From: Simon Davis
Sent: 08 June 2018 11:39
To: Planning.Responses
Subject: FW: 97 Barnham Road, Eastergate - EG/107/17/DOC

Number
S17-03-01 E

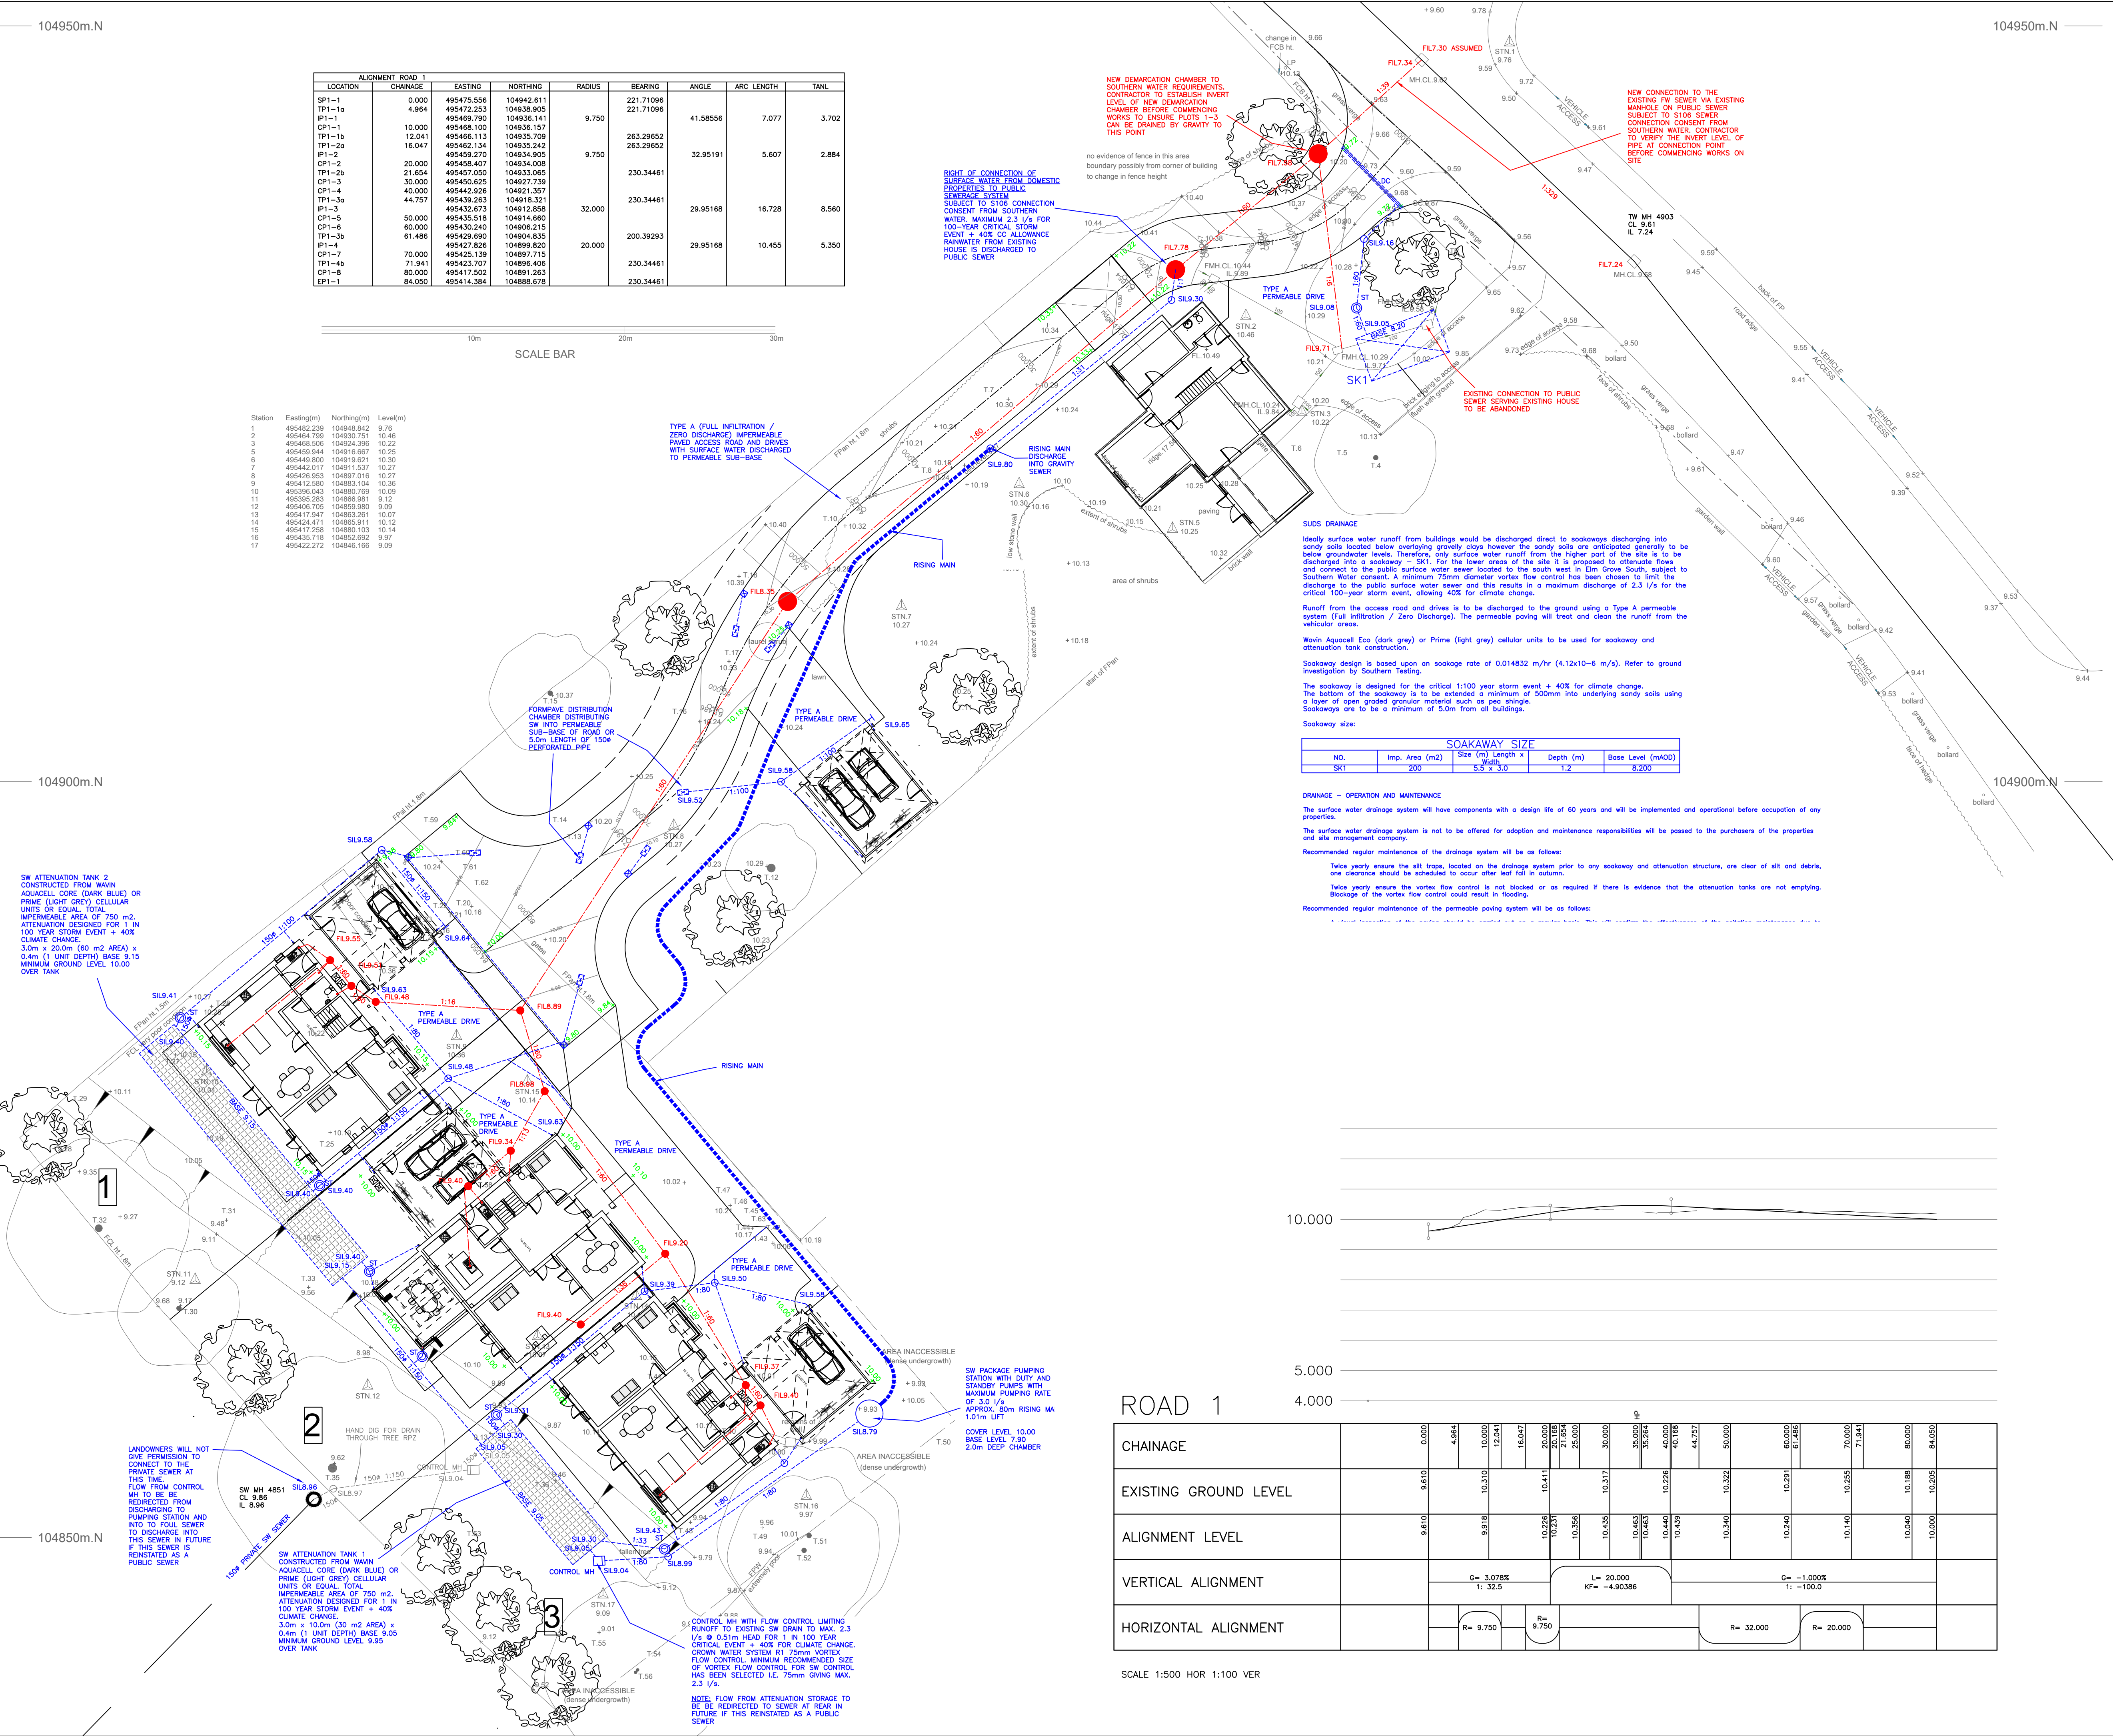
Gerald,
Sorry for the delay in getting back to you. I have reviewed the responses you have provided.
On this occasion, we will let the lack of thrust blocks and cover depths be permitted.
However, we need to see an additional manhole and length of gravity pipe (to be laid at an agreed gradient) at the downstream extent of the rising main. Not including this could result in serious problems with backing up of foul water and blockages occurring as a result.
Regards,
